**Case Officer:** Jordan Campbell

**Recommendation:** Approve

**Proposal:** Erection of two storey rear extension.

SOUTH ELEVATION

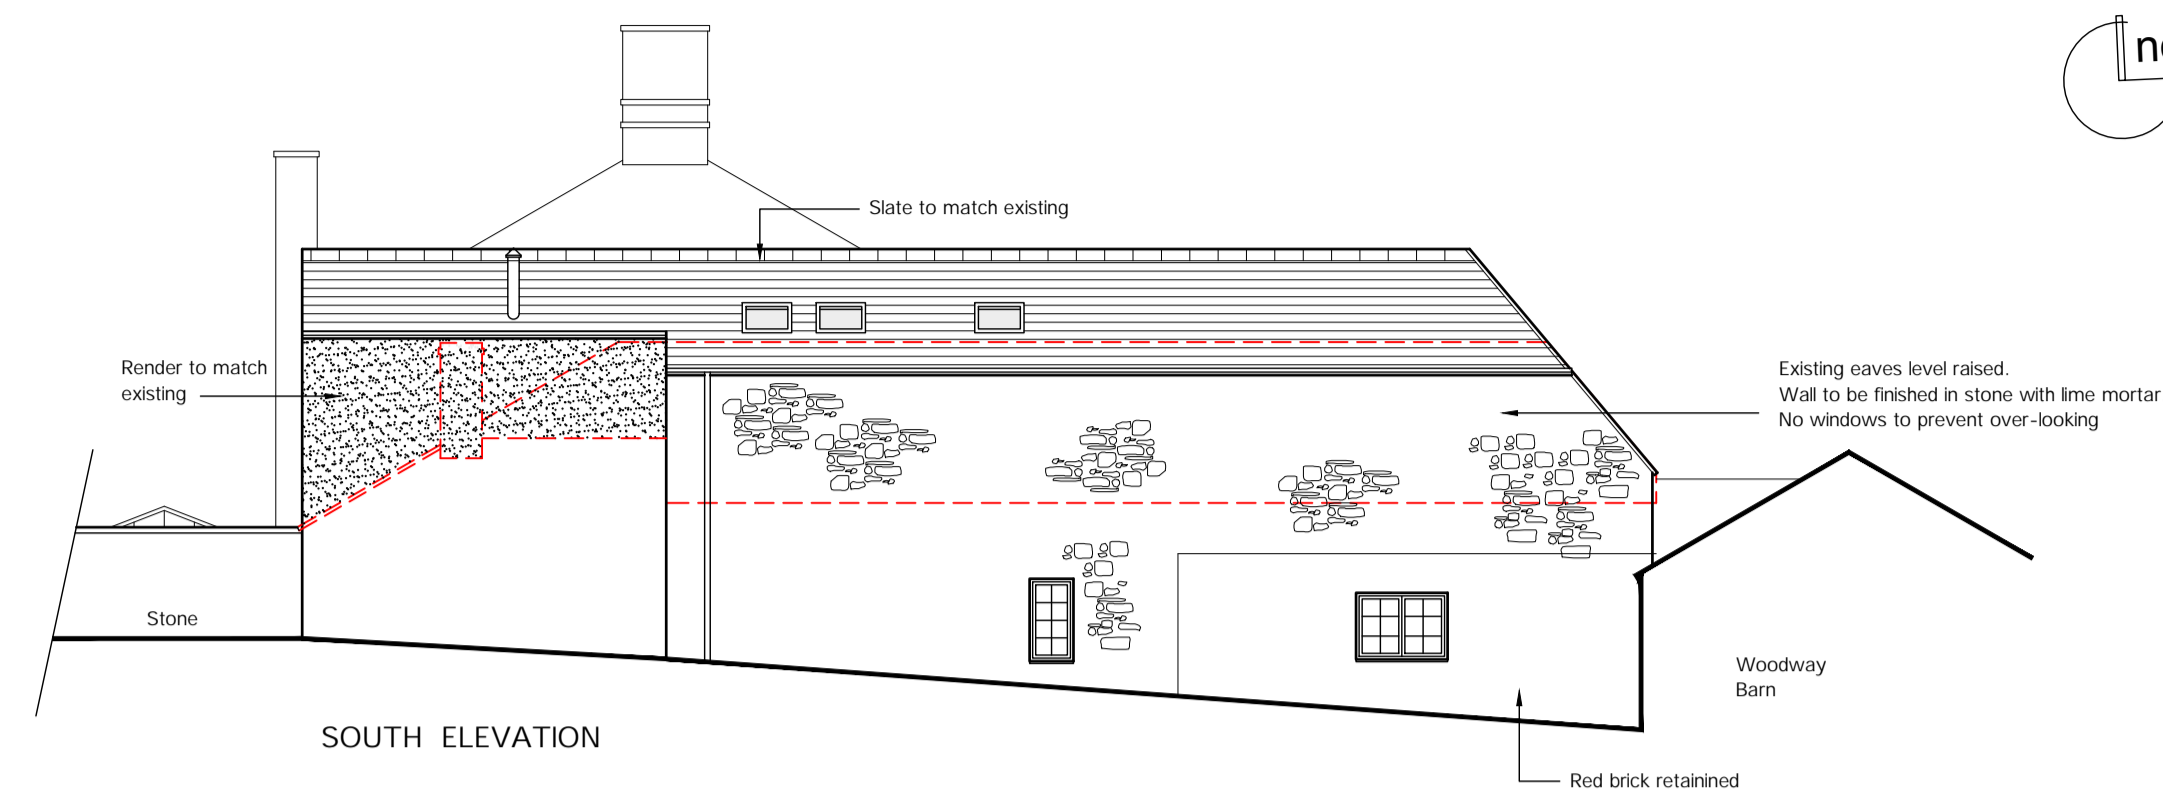
- Subject to conditions for materials and detailing, and to require the proposed x3 roof lights to be set flush with the proposed extension's Southern roof slope, the proposed development would thus comply with Policies C28 & C30 of the CLP 1996, Policy ESD15 of the CLP 2015 and Government guidance contained within the NPPF.

5. The rooflights to be used in the development shall be of a design which, when installed, does not project forward of the roof slope into which they are installed and shall fit flush with the plane of the roof.

NORTH ELEVATION / SECTION

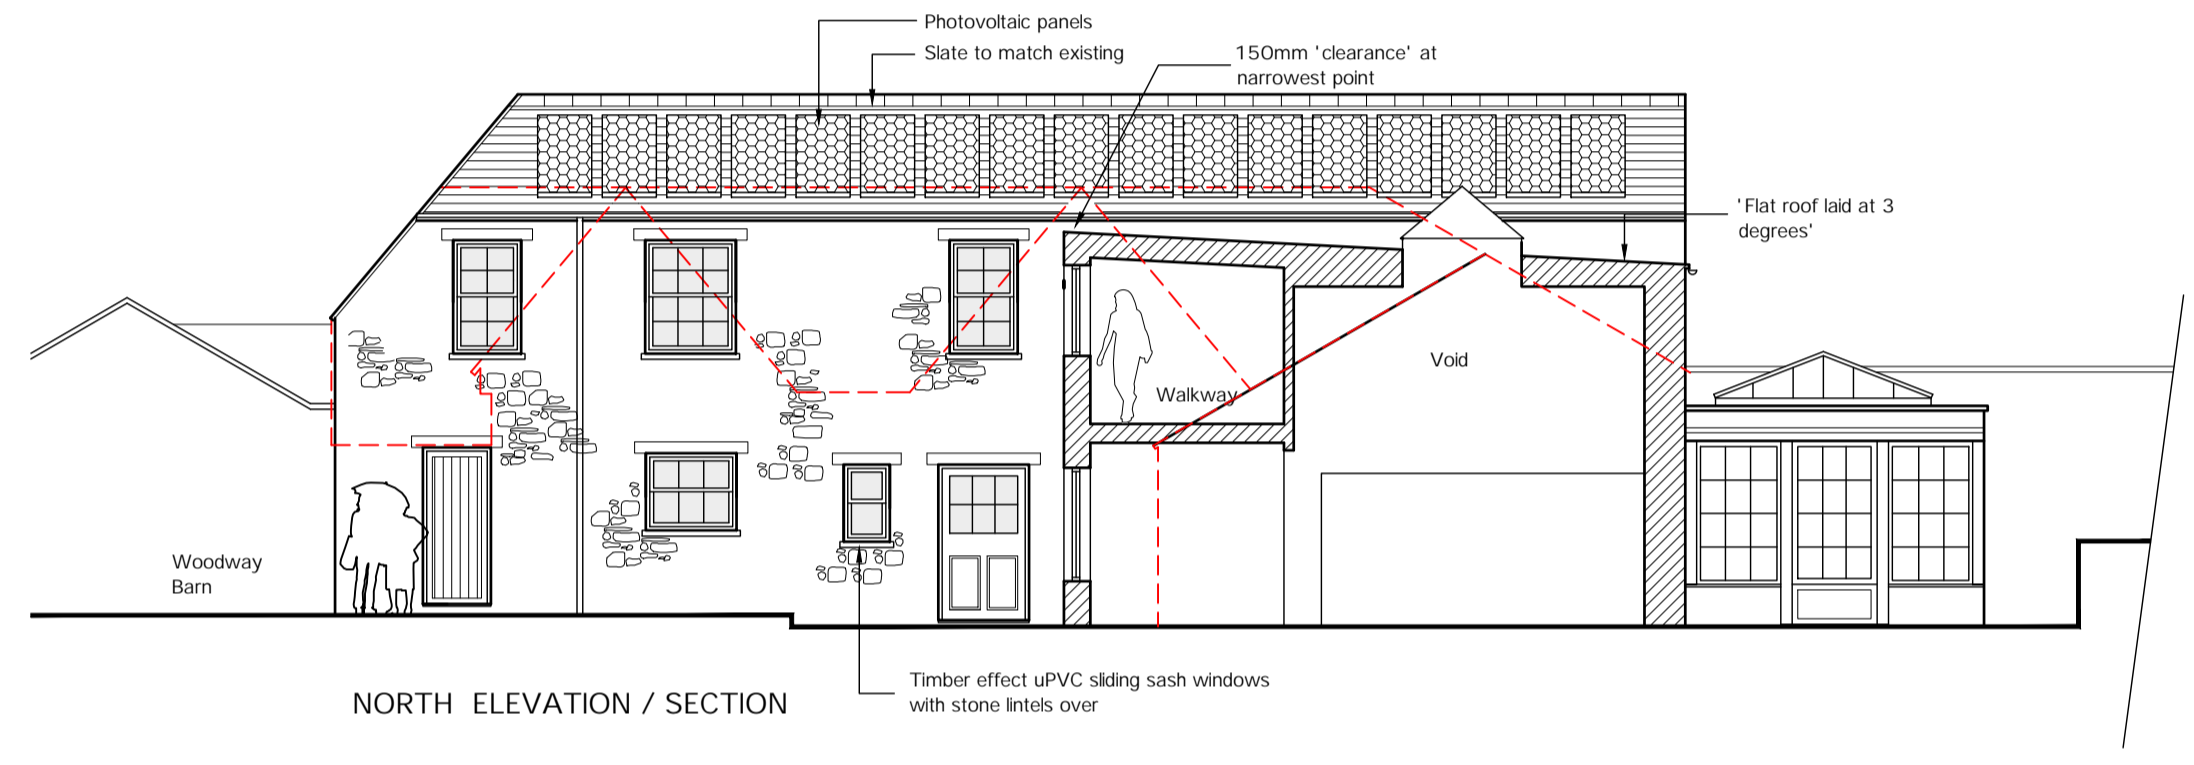
- The proposed development would be externally finished in Stone with lime mortar, with a small section of render to North elevation. The original dwelling is finished in stone, red brick, and render. Thus, the proposed development's materials, stone and render, would harmonise with the original dwelling.

WEST ELEVATION

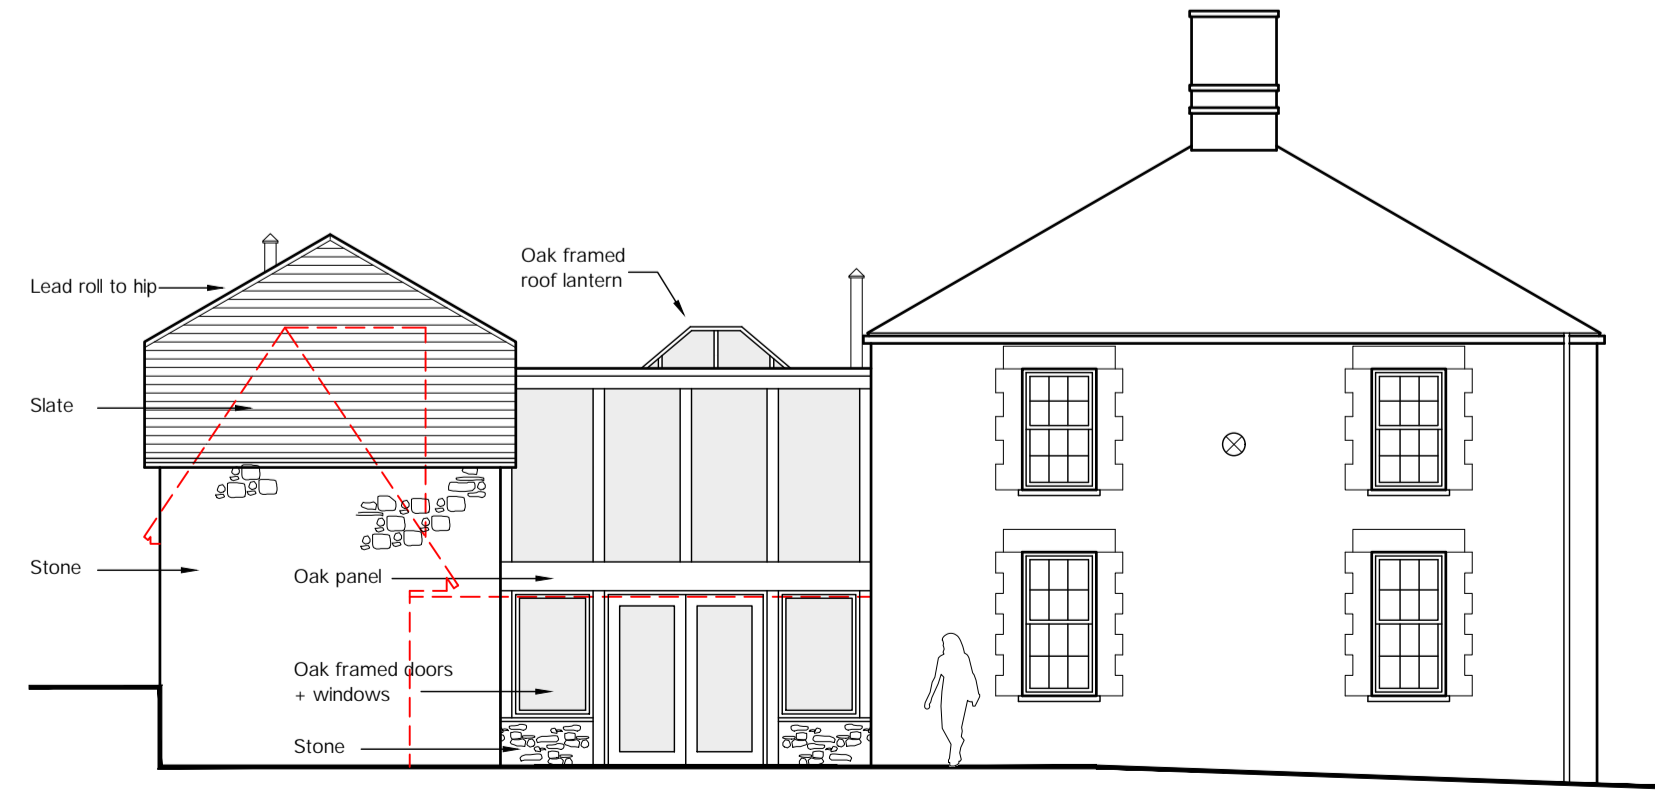
- The form and design of the linking section would be somewhat at odds with the character of the dwelling, particularly given the amount of glazing to the west elevation, but it would be subservient in height and would have little or no impact on the character or appearance of the wider area.
